Our Ref: EN010095

Date: 20 April 2021

### **Application by Alternative Use Boston Projects for an Order Granting Development Consent for the Boston Alternative Energy Facility**

#### **Advice following issue of decision to accept the application for examination**

DRAWING No. **PB6934-RHD-01-ZZ-DR-4020** SUITABILITY **S0** REVISION **0**

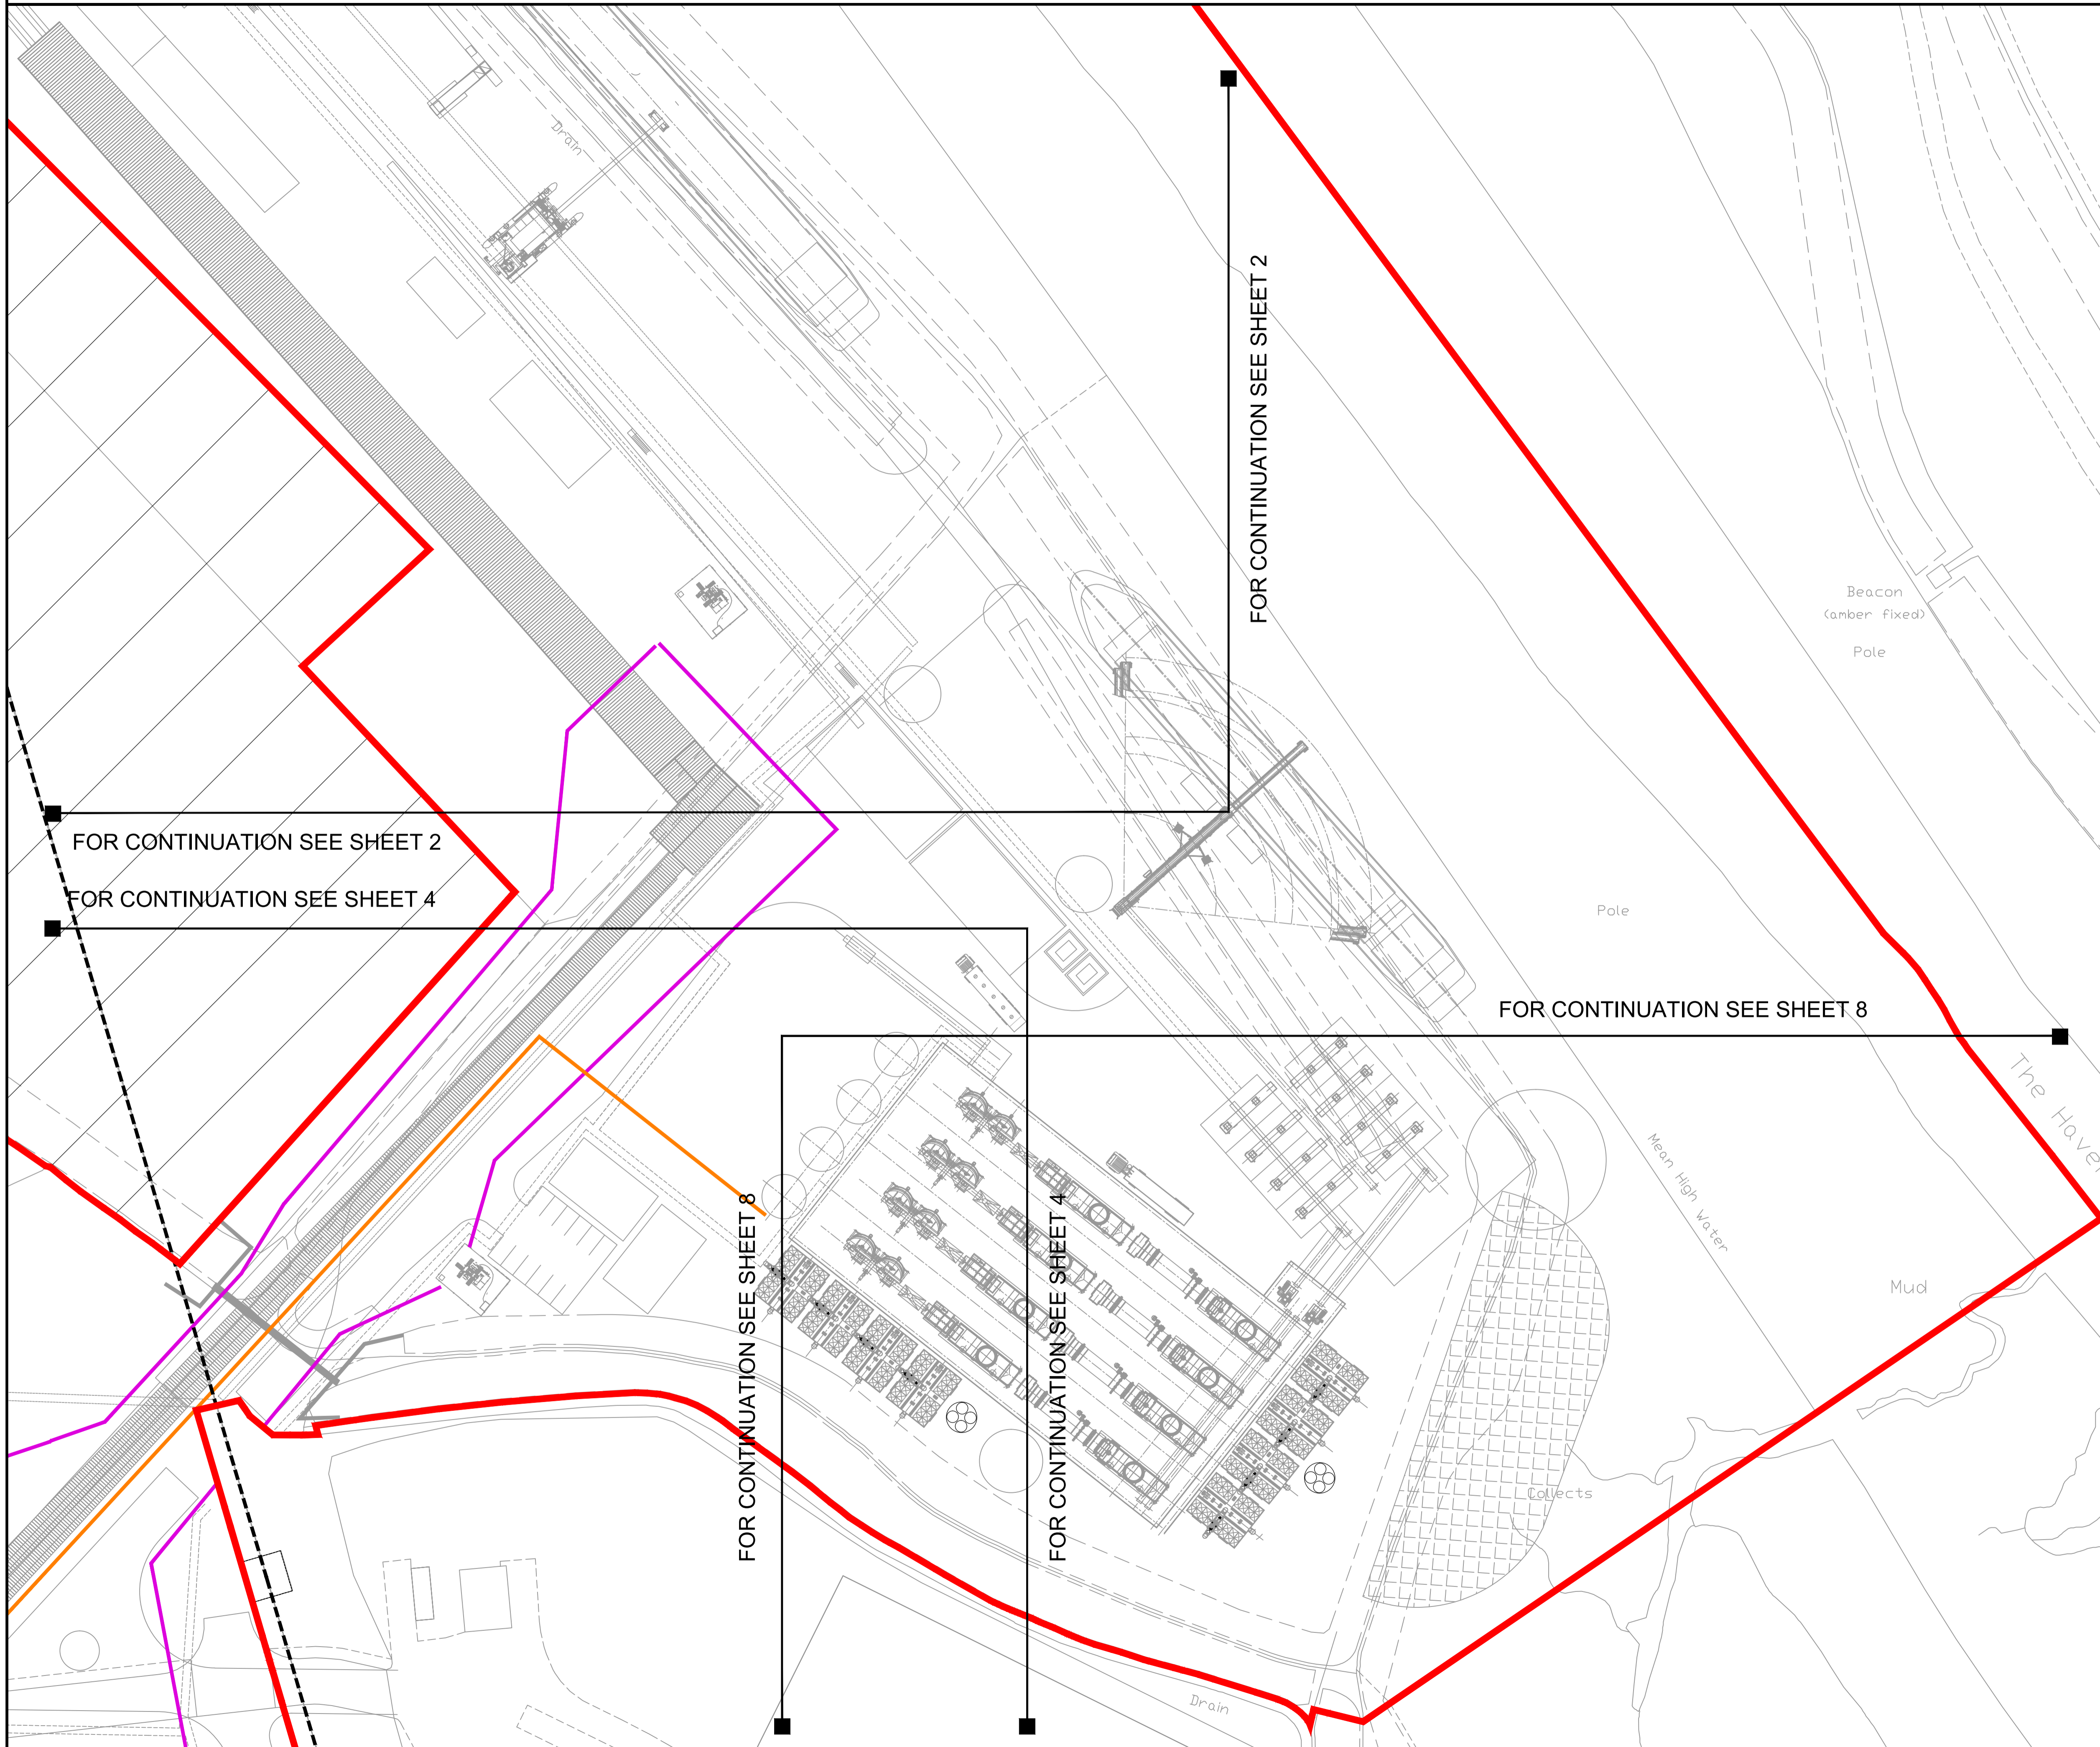
On the key plan 'SHEET 5 OF 7' should refer to 'SHEET 5 OF 8'.

The Applicant may wish to note the above and correct any errors when submitting updated documents in the Examination.
